Y/154/21/HH & Y/155/21/L

Hobbs Farm House Bilsham Road Yapton BN18 0JY

Conversion of existing outbuilding to ancillary accommodation to main dwelling. (This application may affect the setting of a listed building).

PROPOSED REAR ELEVATION AT 1:100 SCALE
SOUTH WEST

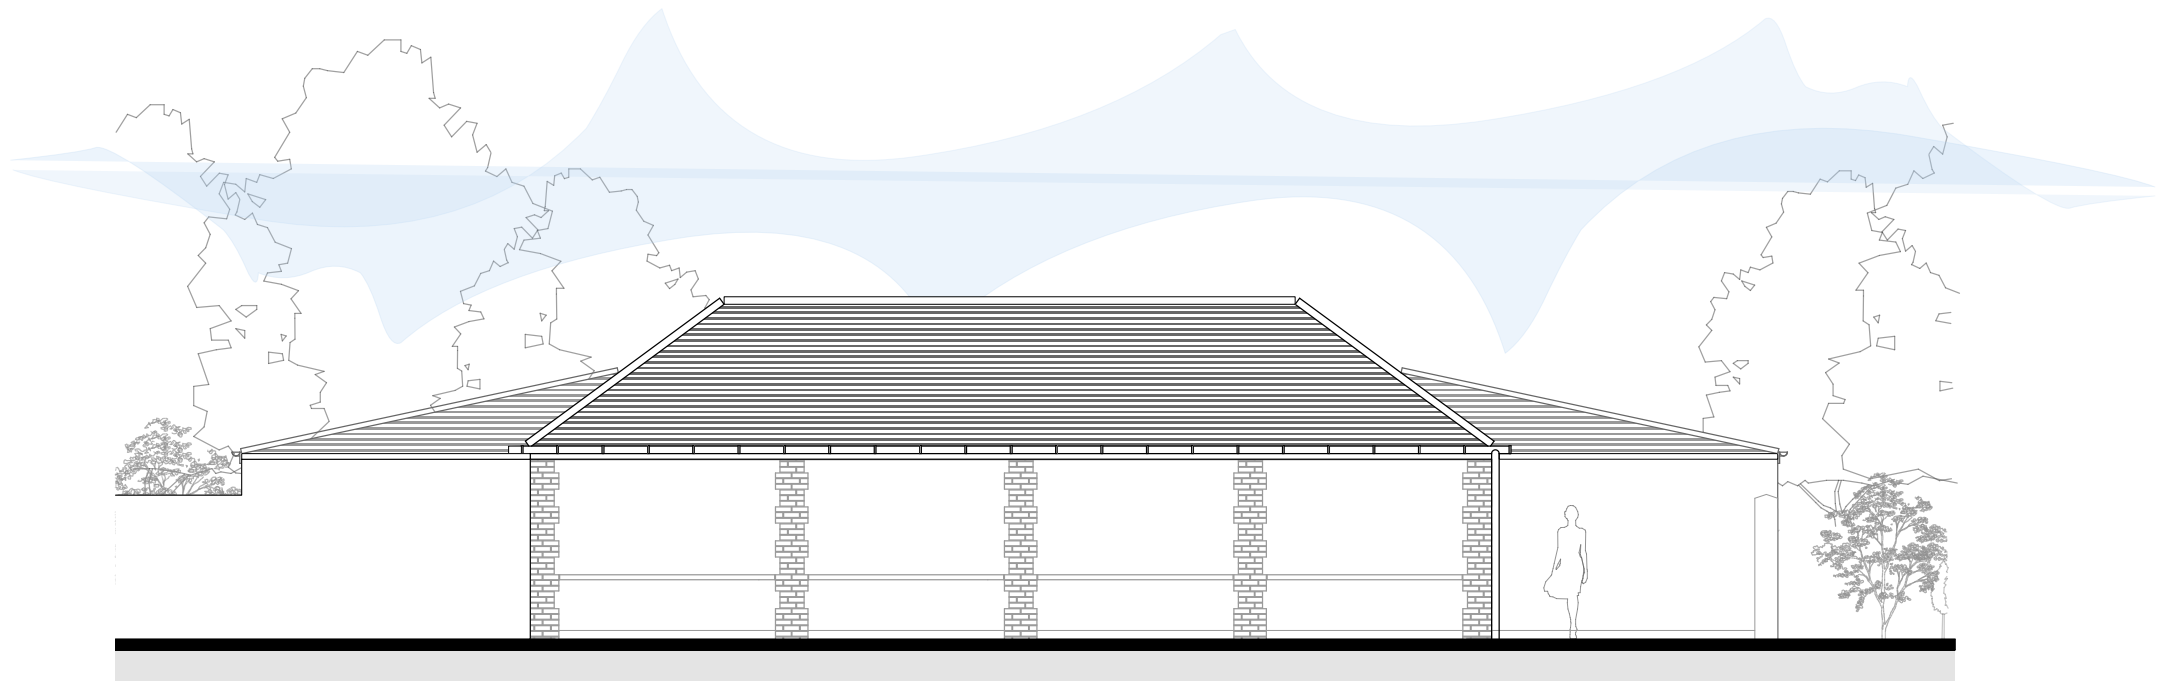
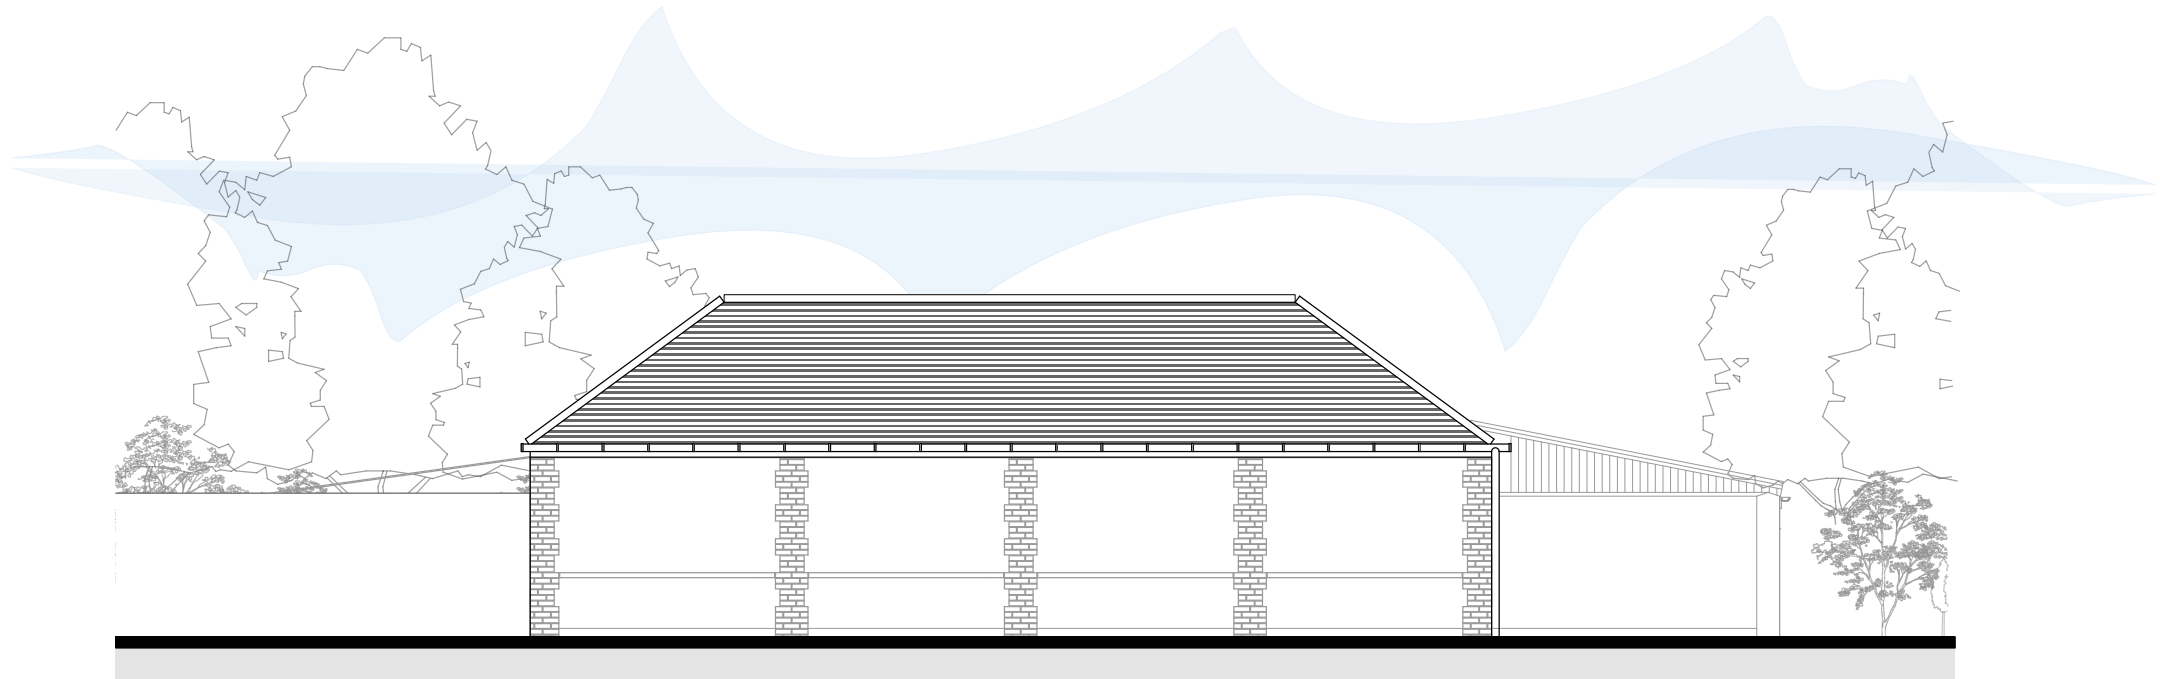
Whilst the use of the double glazing is not a concern in this context (utilising the slimmer units), I would want to ensure that the frames, detailing and colours are appropriate for the building, and be designed so that they are as slender as possible. Further it is also suggested that the two large areas of glazing in the existing cart openings should be recessed so as to create a shadow line and reduce the impact of the glazing (which can cause reflections).

If minded to approve the application, I would like for a condition regarding the windows/doors, and any other materials to be used in the building. Details of the windows and doors should be at an appropriate scale so that they can be fully understood in the context of this building. I would also want to understand the colours of the windows and doors.

CLIENT	Mr. & Mrs. R. Head	REVISION A4 10.07.18
SITE	Hobbs Farmhouse, Blisnam Road, Topham	
PROJECT	Conversion of Existing Outbuilding	
DRAWING	001 Existing & Proposed Floor Plans	
DATE	10.07.18	AUTHOR PMG 18
STATUS	PMG 18	SCALE 1:100 @ A3

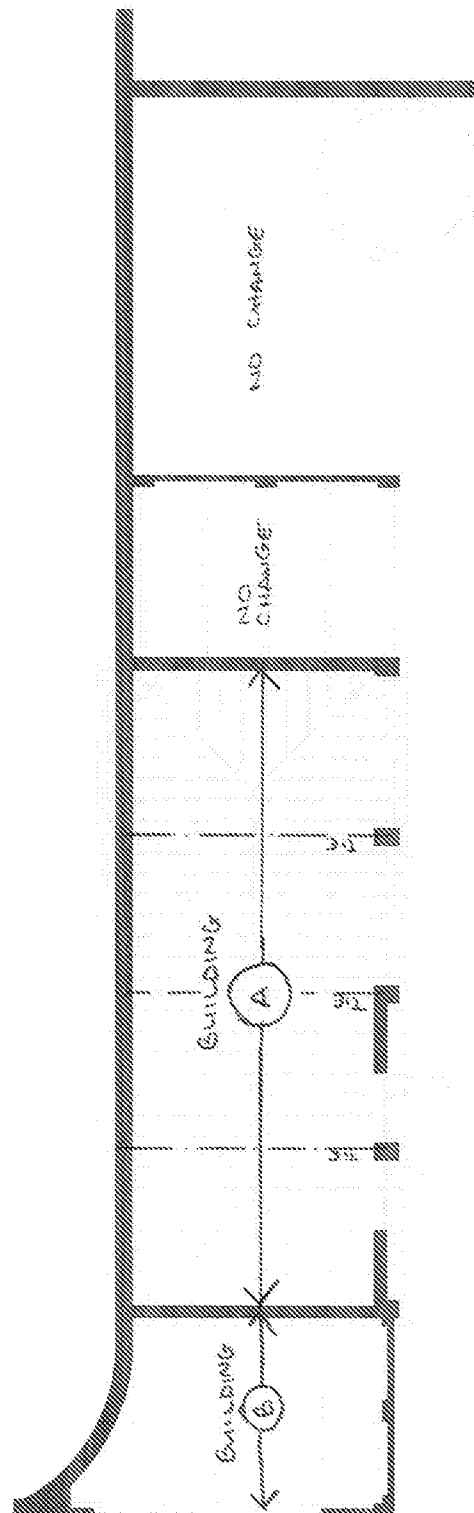
The layout of the building appears to retain as much of the existing open character as possible including the retention of the existing barn style pedestrian doors, one of which will act as a shutter to the internal space. It is also positive to note that the internal spaces will remain vaulted, which will help to retain the open character of the building.

Whilst the creation of an internal opening will lead to the loss of some historic fabric, it is considered that the scale of the loss is such that it will have limited impact upon the building as a whole. The bricks should be kept and retained for use as part of any repairs to the building.
